**NEW HIGH SCHOOL IN BUNGENDORE
APPLICATION NO. SSD-14394209**

I refer to the above state-significant development application.
This is an objection to SSDA 14394209 re the current proposal in regard to a High School in Bungendore.

PROPOSED SITE PLAN

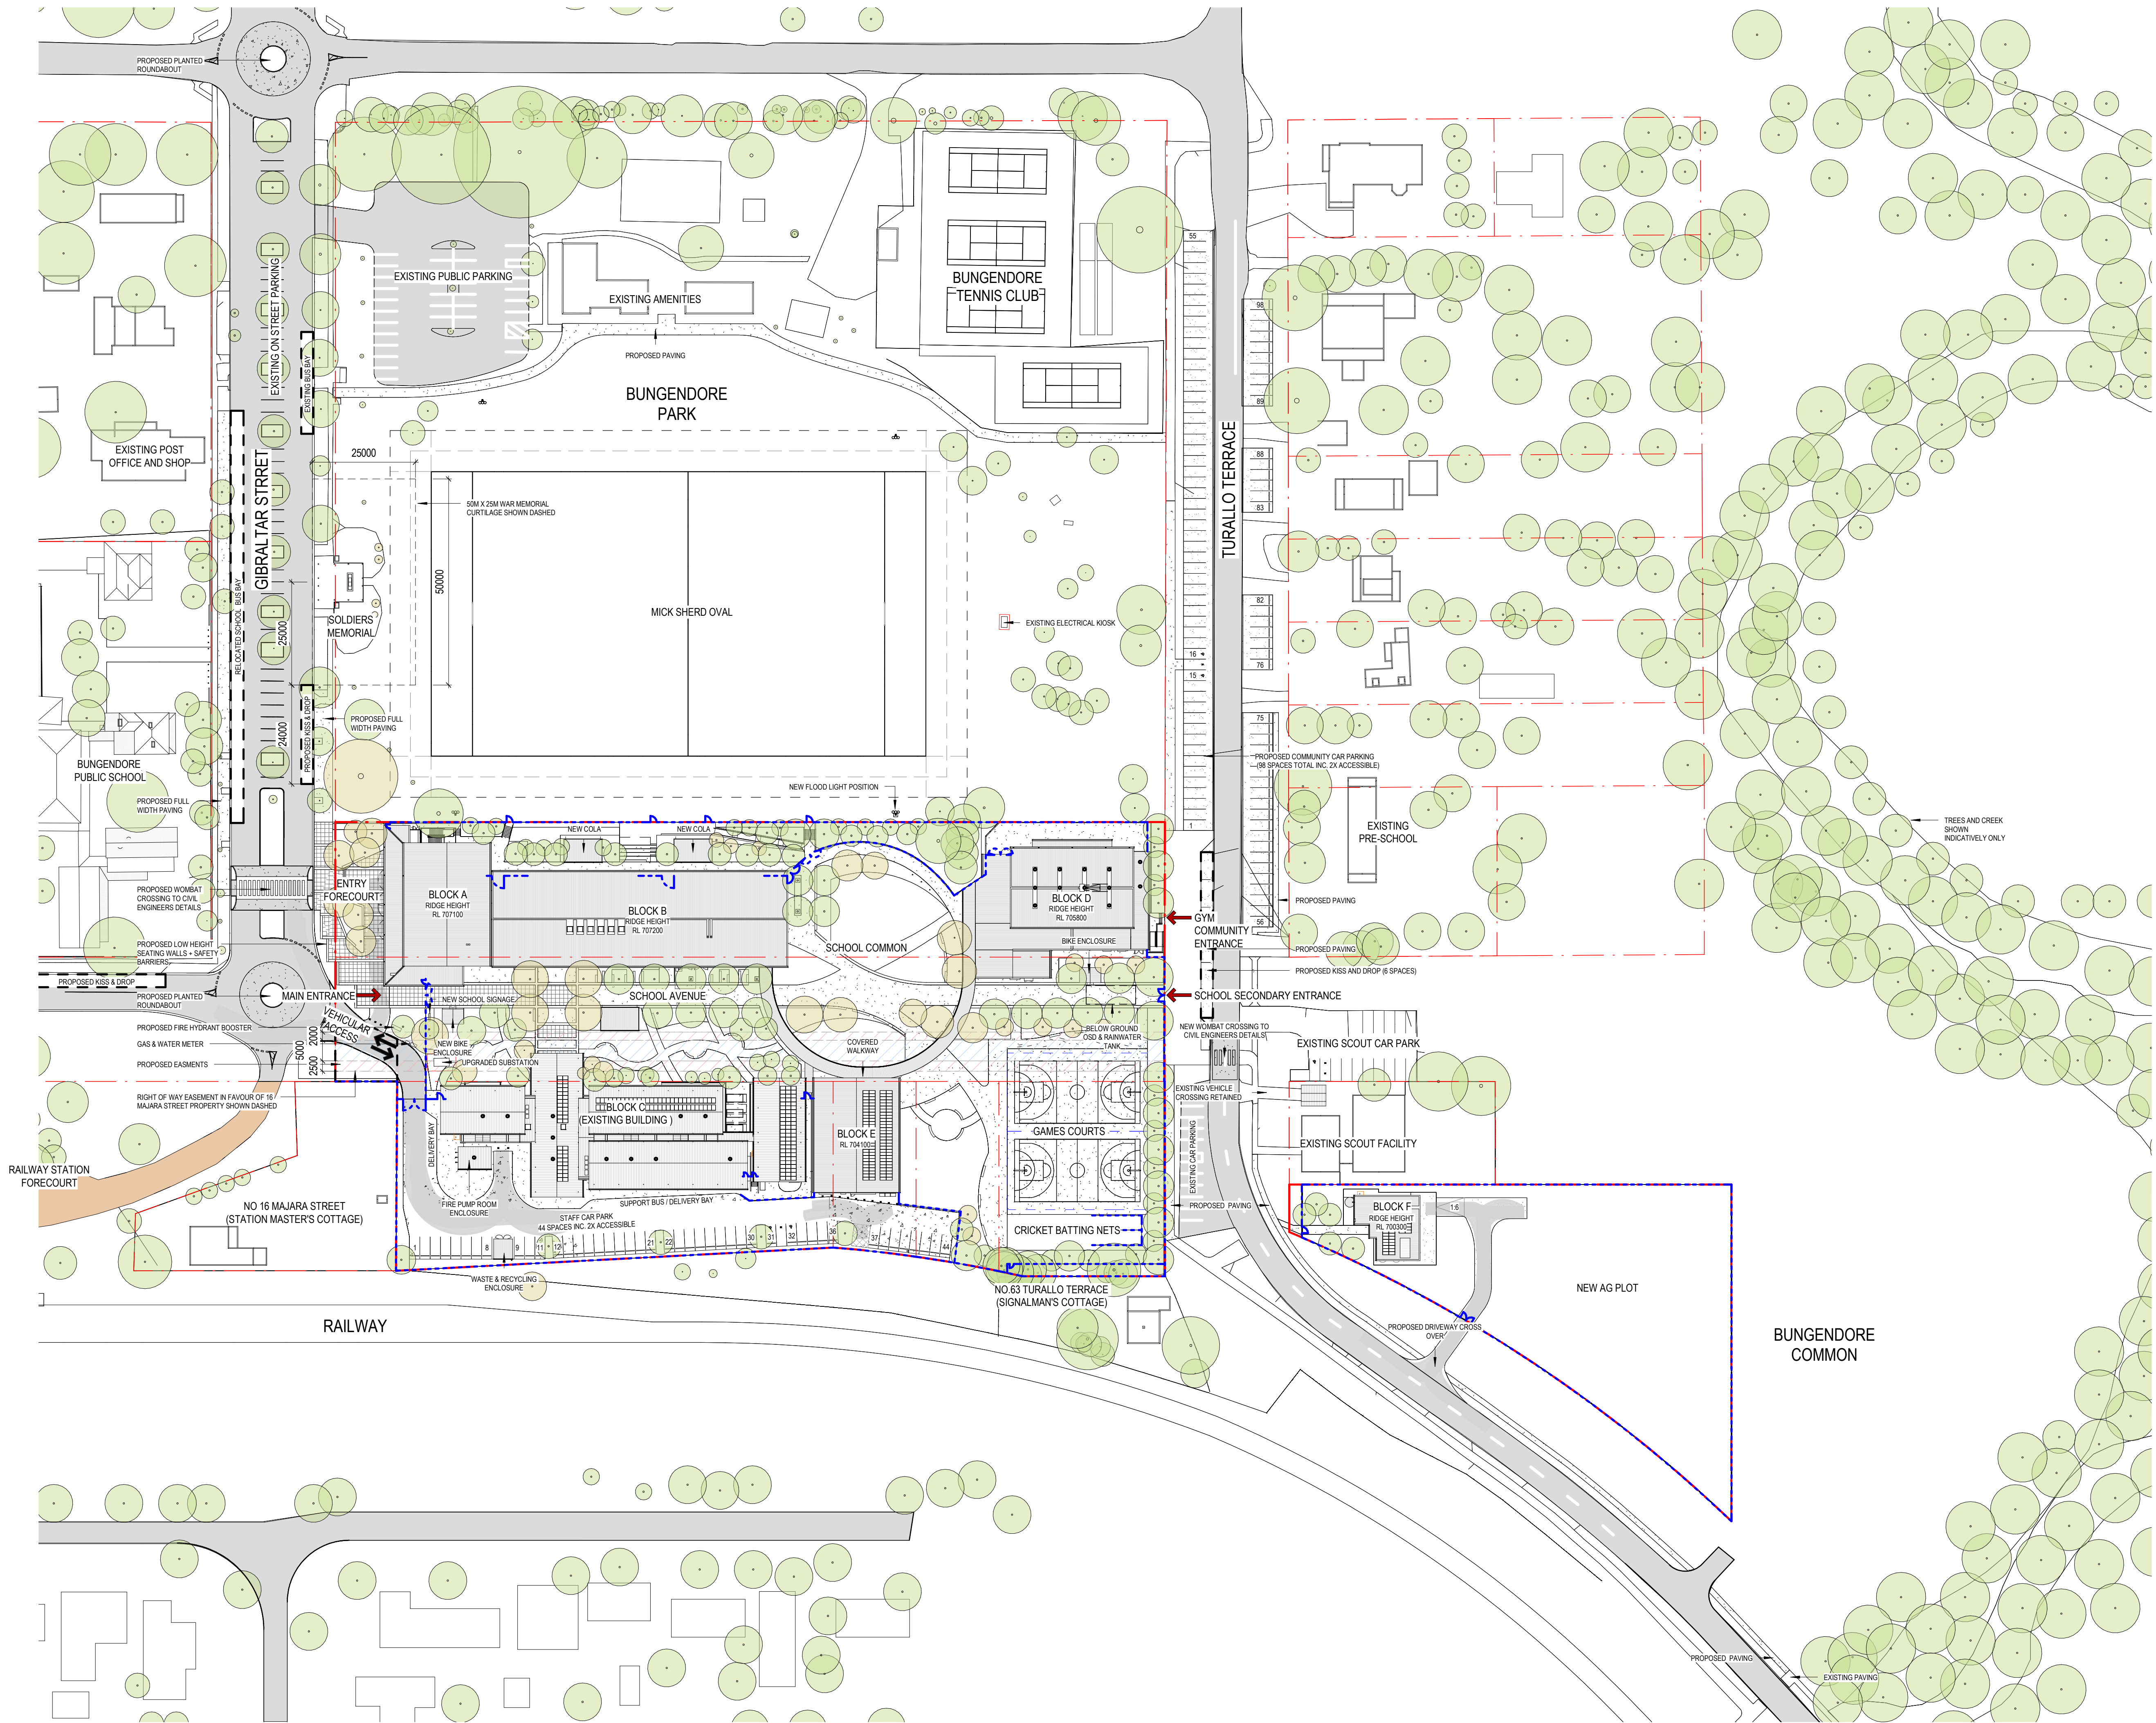
I Object to fencing around Mick Sherd Oval

At consultation sessions in August 2019 we were advised there would be no fencing of oval, This SSDA now states low height 1m chainwire fencing and timber post and rail fencing facing Mick Sherd oval currently and 2.1 m fencing on boundaries around the park.
